Please treat comments from Ms Dolan as a rep Anita Gardner Principal Planning Officer, Directorate of Place

> Subject: WSCC Highways Authority planning services report on

> FG/46/21/PL Dated 6 April 21

> I refer you to the above report which relates to a proposal which will have the southern edge of my 8ft wide driveway as its northern boundary.

Drawing Title 028_02 Proposed Ground Floor Plan Land between 11A The Grove and 30 Brook Lane, Ferring					
Completion date 17/03/2021					
Drawn by Guy Rochez ARB					
Scale: 1:100@A3					
Print Size: A3					
Notes:

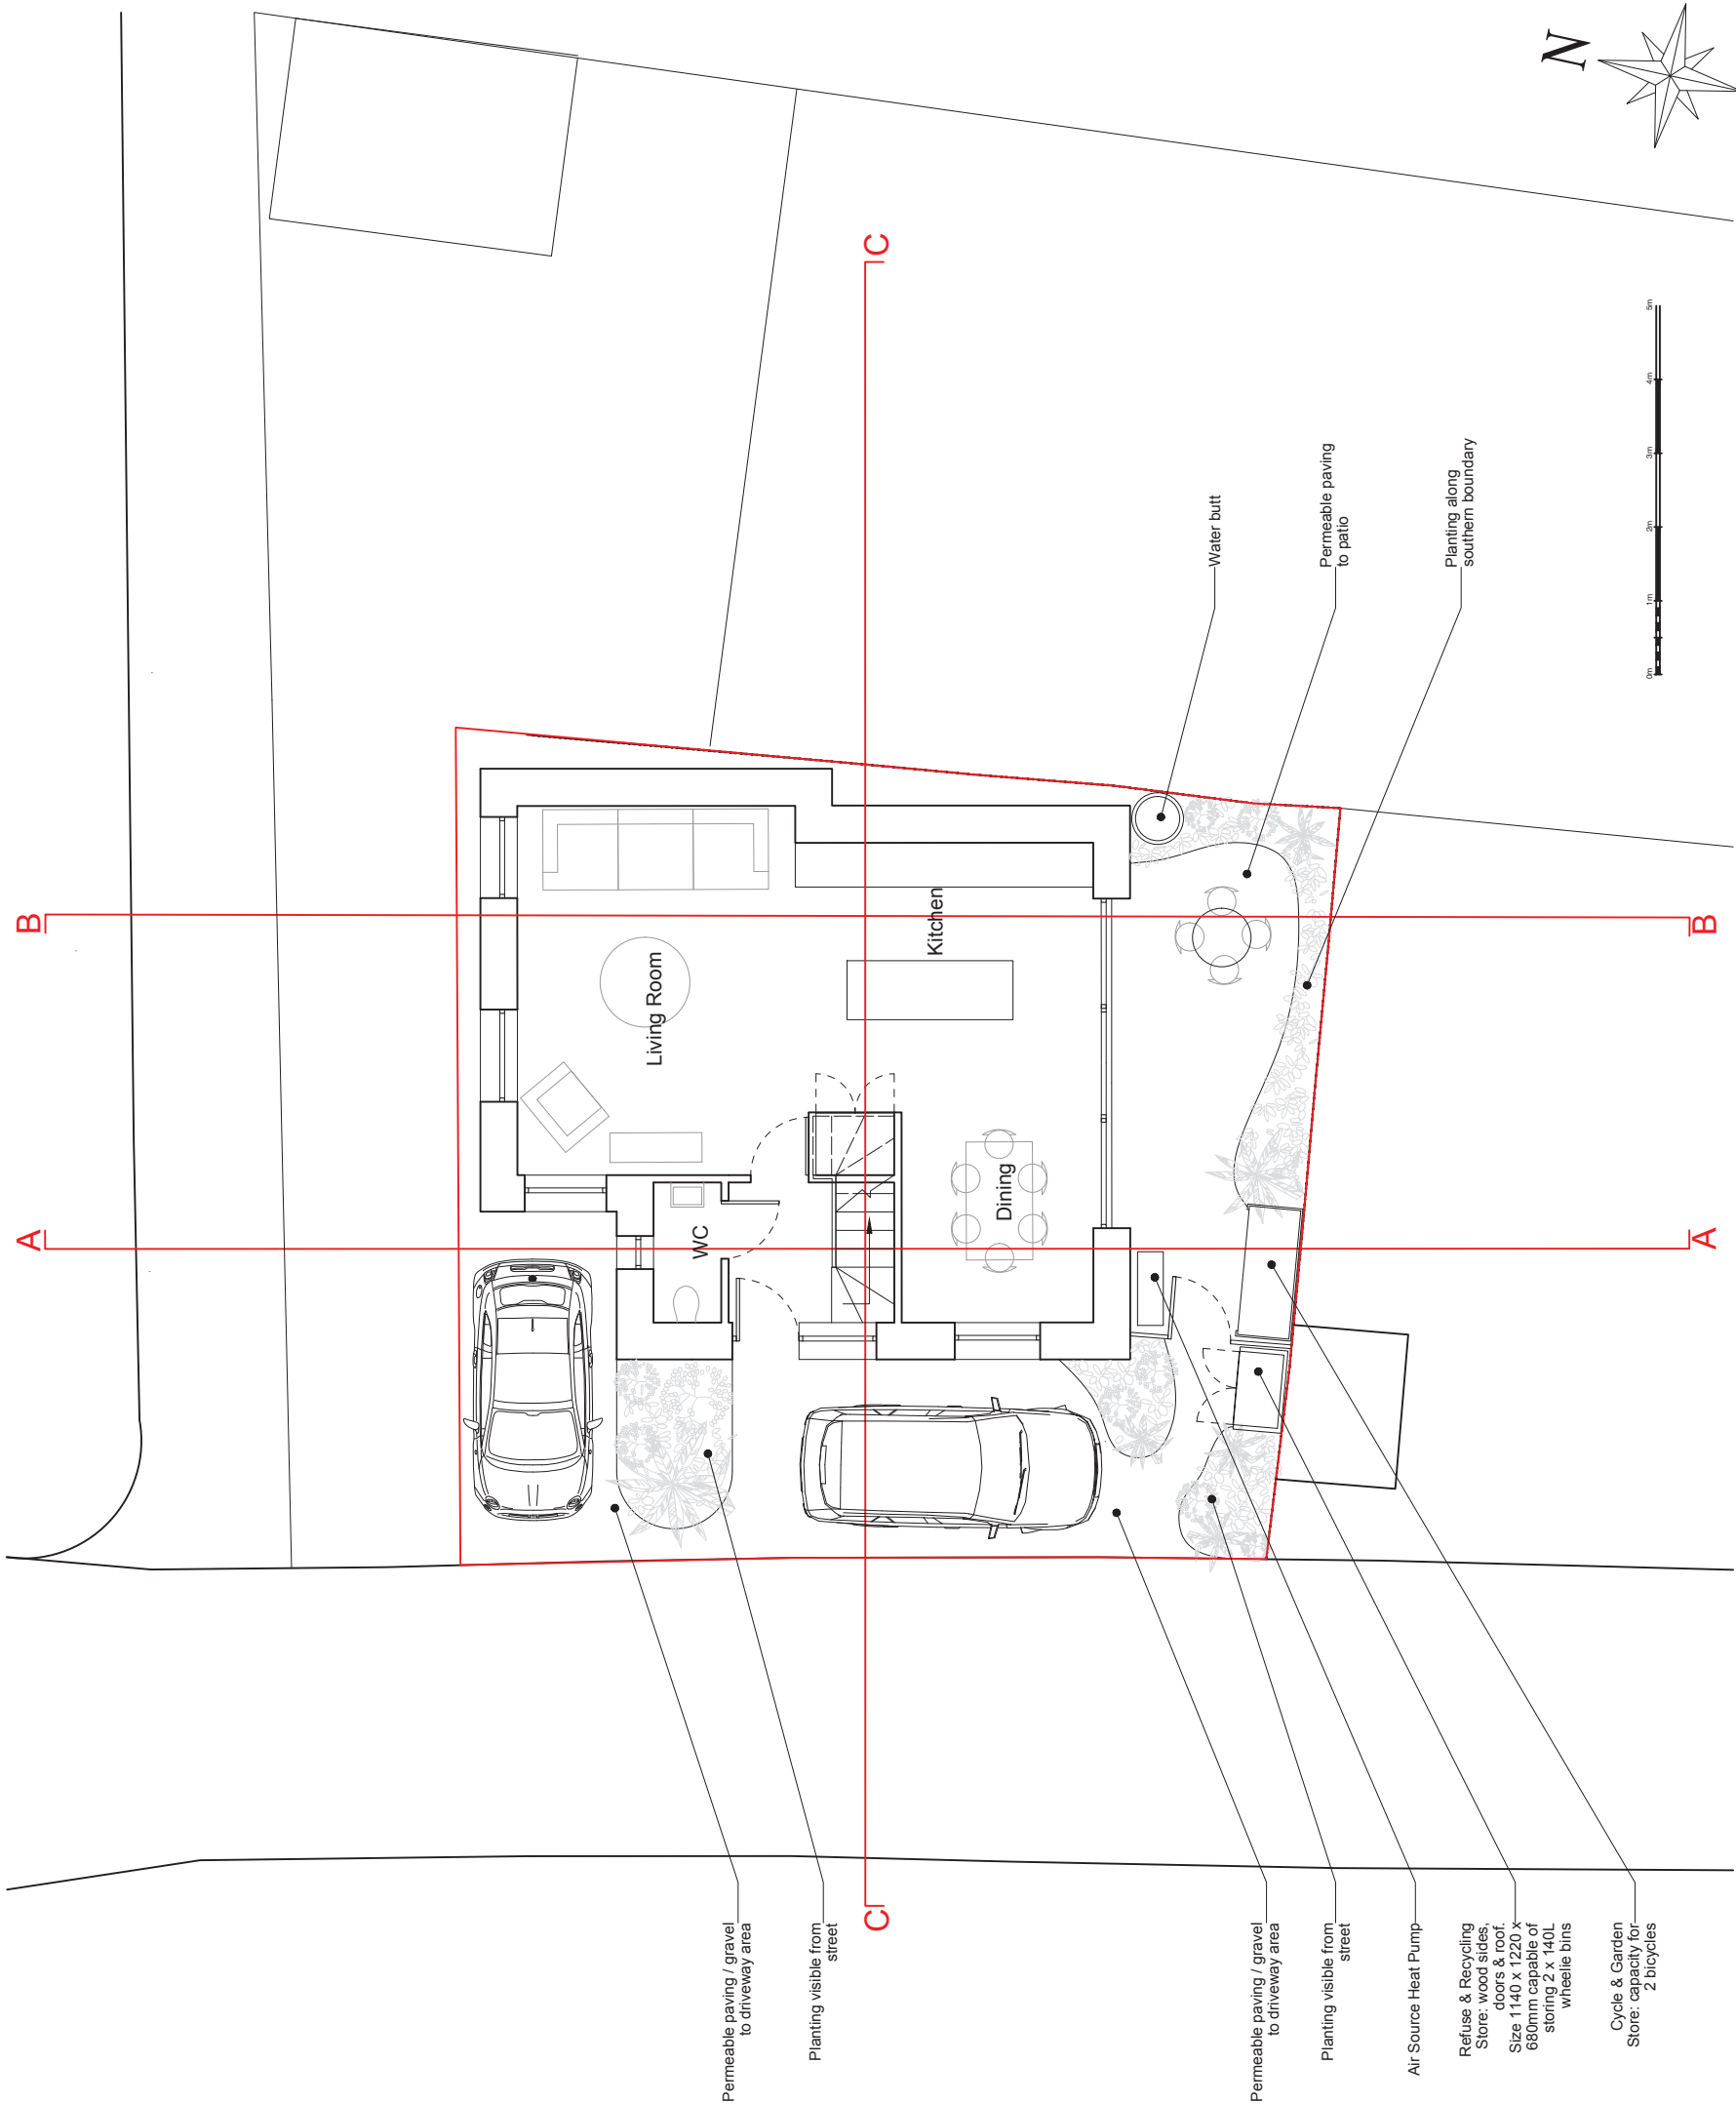
> I note with concern that there is no consideration being made for the line of sight from where my driveway exits on to The Grove. There is a proposed parking space set tight up against the exit of my driveway right to the road itself, obscuring my line of sight. To make the matter worse, the space is too small for an average car meaning anyone parked there in an average car will have part of their car poking out into the road decreasing my line of sight even further.

> I wonder if you would kindly have another look at this proposal? I

> would like to be reassured that the line of sight from my driveway

> will be kept clear (is it called a visibility splay?)
